Appeal Decision

Appeal Ref: APP/R5510/D/23/3332025

24 Spencer Avenue, Hillingdon, Hayes UB4 0QX

- The appeal is made under section 78 of the Town and Country Planning Act 1990 against a refusal to grant planning permission.
- The appeal is made by Mrs Devinder Jabbal against the decision of the Council of the London Borough of Hillingdon.
- The application Ref 35894/APP/2023/2092, dated 14 July 2023, was refused by notice dated 8 September 2023.
- The development proposed is to extend the existing 3.0 m extension to a single storey 6.0 m rear extension.

Drawing No HL-07_PL/02 Rev.

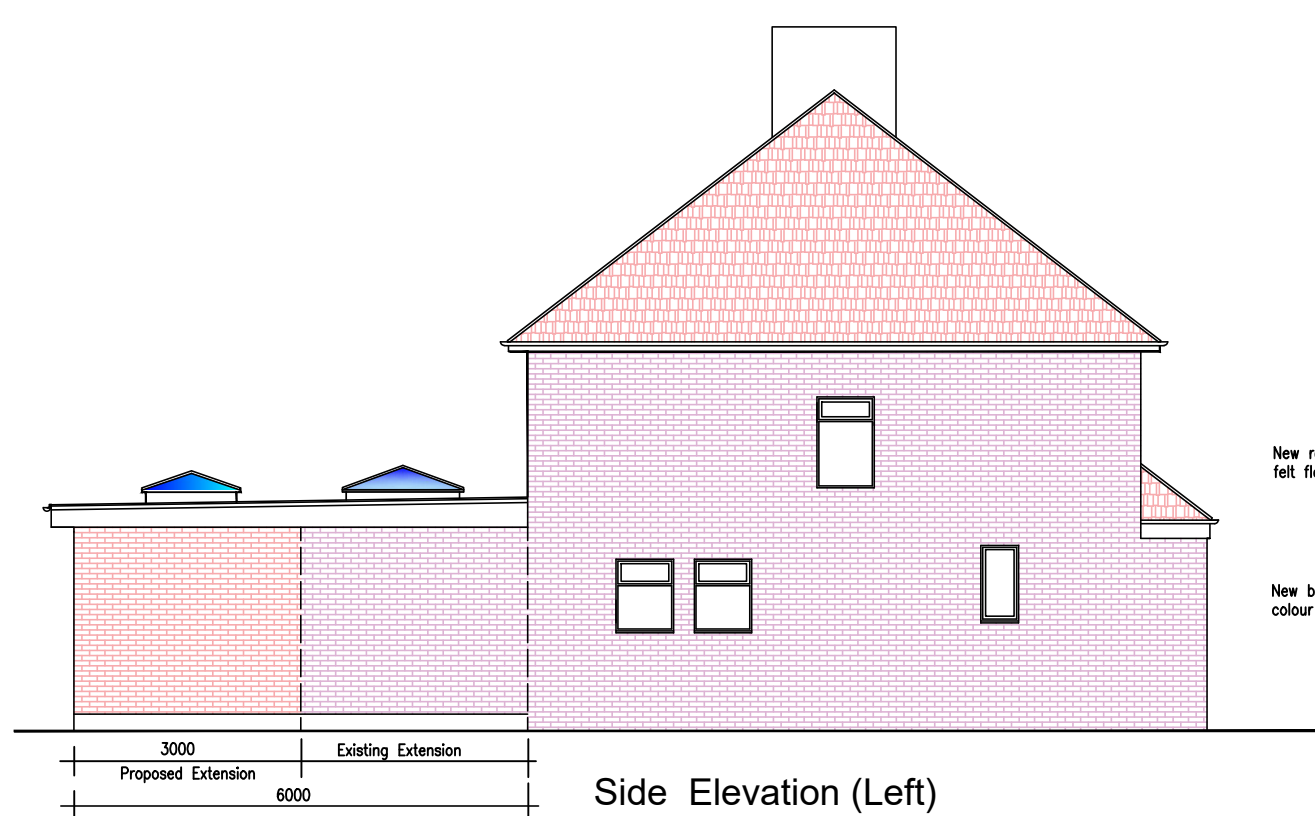
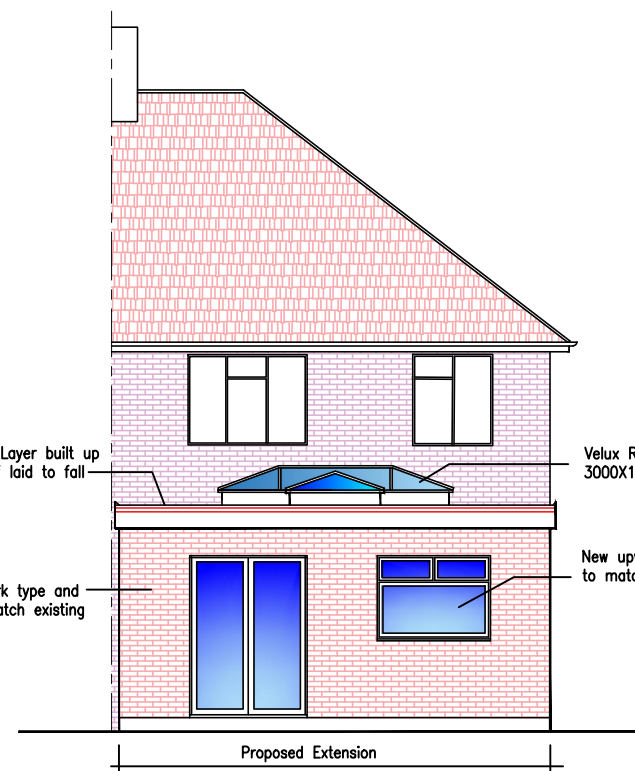
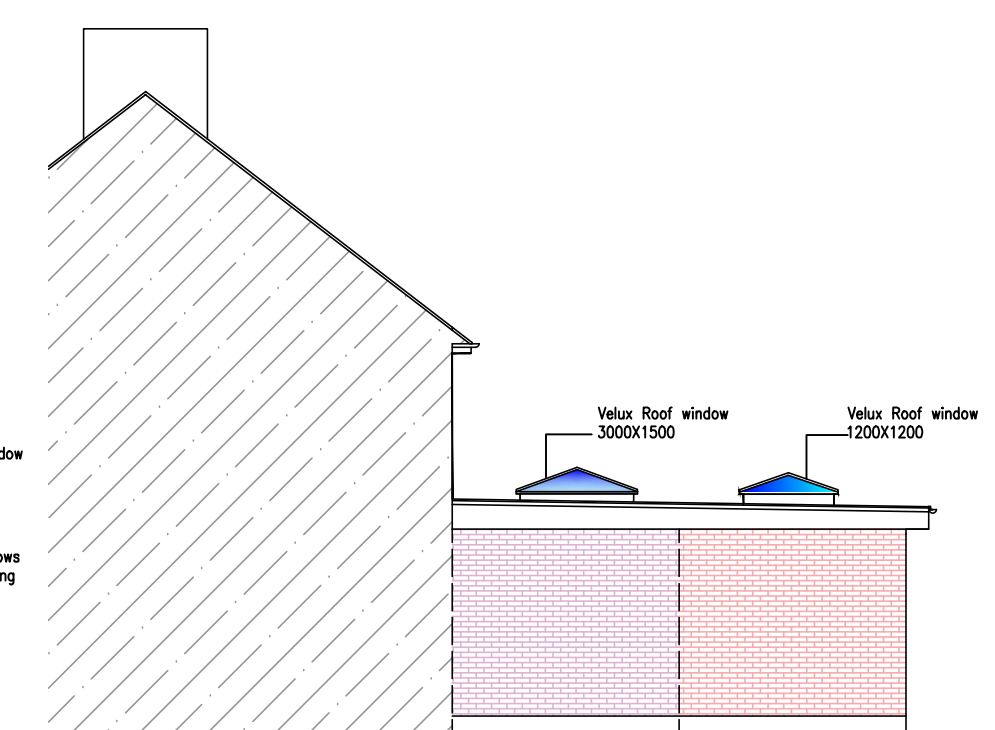
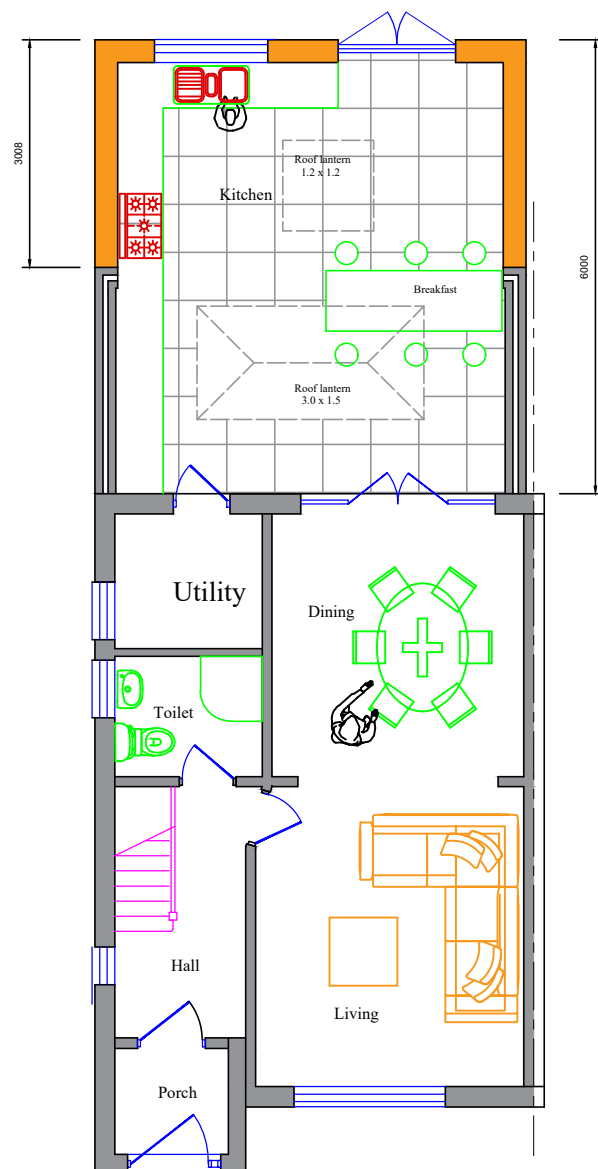
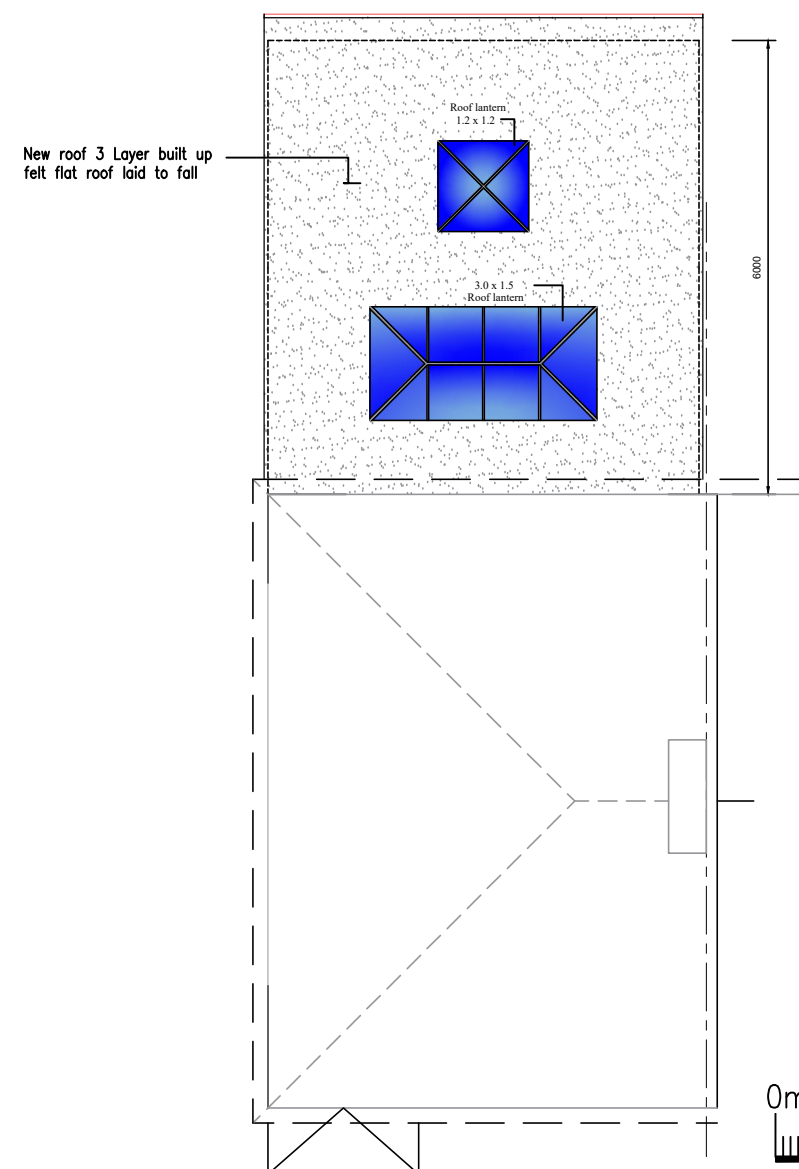
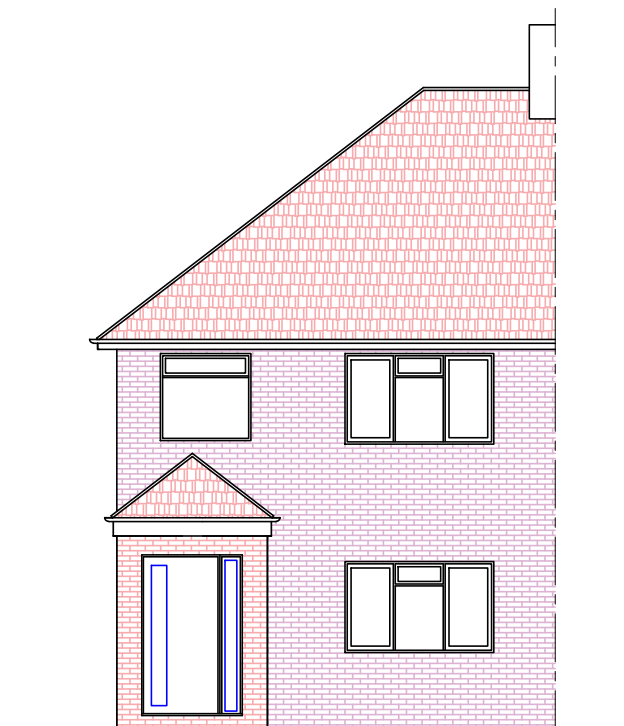
4. 22 and 24 Spencer Avenue are a pair of semi-detached houses. No 24 has a 3m deep single storey extension at the back. The proposal would add another 3m of depth to this, replacing the existing extension's lean-to roof with a combined flat roof.
5. Policy DMHD1 of the Hillingdon Local Plan Part 2 Development Management Policies (LP2) states that in situations like this single storey rear extensions should not exceed 3.6m in depth, so that the proposed cumulative depth of 6m conflicts with the policy. The appellant suggests that policy DMHD1 is out of date because it would limit development to less than is allowed as permitted

6. No 22 has not been extended next to No 24 at the back, except for an open canopy that leaves a main rear ground floor window in the original back wall, close to the shared boundary. The proposed extension would be about 3m tall - significantly higher than the existing approximately 2m high fence dividing the back gardens. At that depth and height, it would form a substantial structure enclosing views from the rear window and looming over the adjacent garden area. It would therefore be intrusive on the outlook from the rear of No 22.

7. I note that the roof of the combined extension would partly be lowered due to the replacement of the existing lean-to roof. The higher part of the existing roof is, however, close to the main rear wall where views from No 22's rear windows are screened by the canopy and would in any case be acutely angled. The existing lean-to roof therefore has little effect on No 22's outlook at present and its partial lowering would not balance the harm caused by the introduction of a much deeper section of high wall next to the boundary.

8. The extension would sit to the north-west of No 22's rear window and adjacent garden area, in a position where it would cause direct overshadowing for only a relatively small part of the day, for a relatively small part of the year. The back of No 22 would furthermore continue to receive daylight (indirect light from the sky) from a reasonably wide aspect. I therefore find no significant harm from loss of light.

10. Although I find no objection in terms of light, I nevertheless conclude that the proposal would unacceptably harm neighbours' living conditions at No 22 next door due to the effect on the outlook from that property. It conflicts with LP2 policies DMHB11 and DMHD1, which aim to ensure that development does not adversely impact on the amenity of adjacent properties, with no unacceptable loss of outlook.
